Please ask for: Sian Eggington
Email: sian.eggington@terraquest.co.uk
Telephone: 0121 2341390
Our Ref: EP/100/20/HH
Your Ref:
Date: 23rd September 2020

Application for Planning Permission for Works or Extension to a Dwelling

Development: Car width hard standing block paved surface for car on front garden
Location: 10 Copse View East Preston BN16 1AY

10 Copse View, East Preston, Littlehampton, BN16 1AY

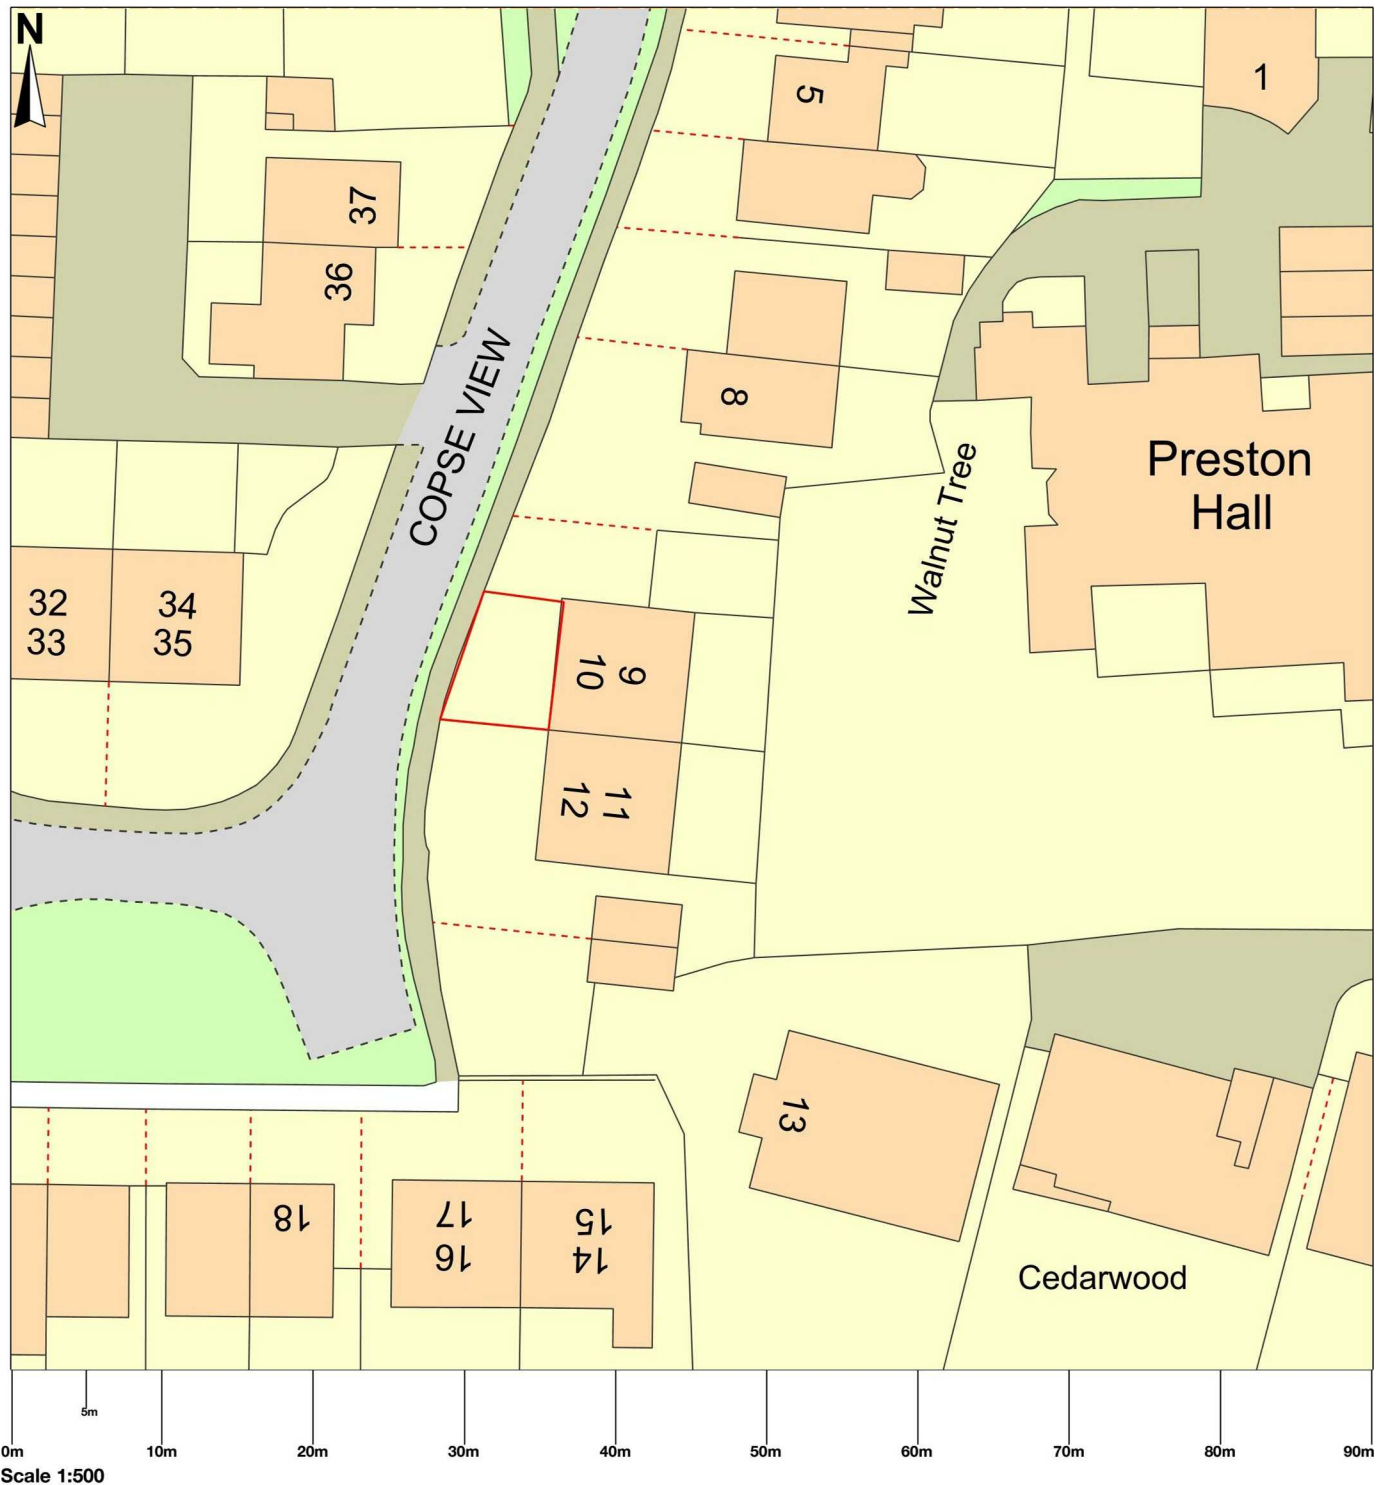
Location Plan: You are required to have a solid red outline around the proposed site on the location plan. Please amend,
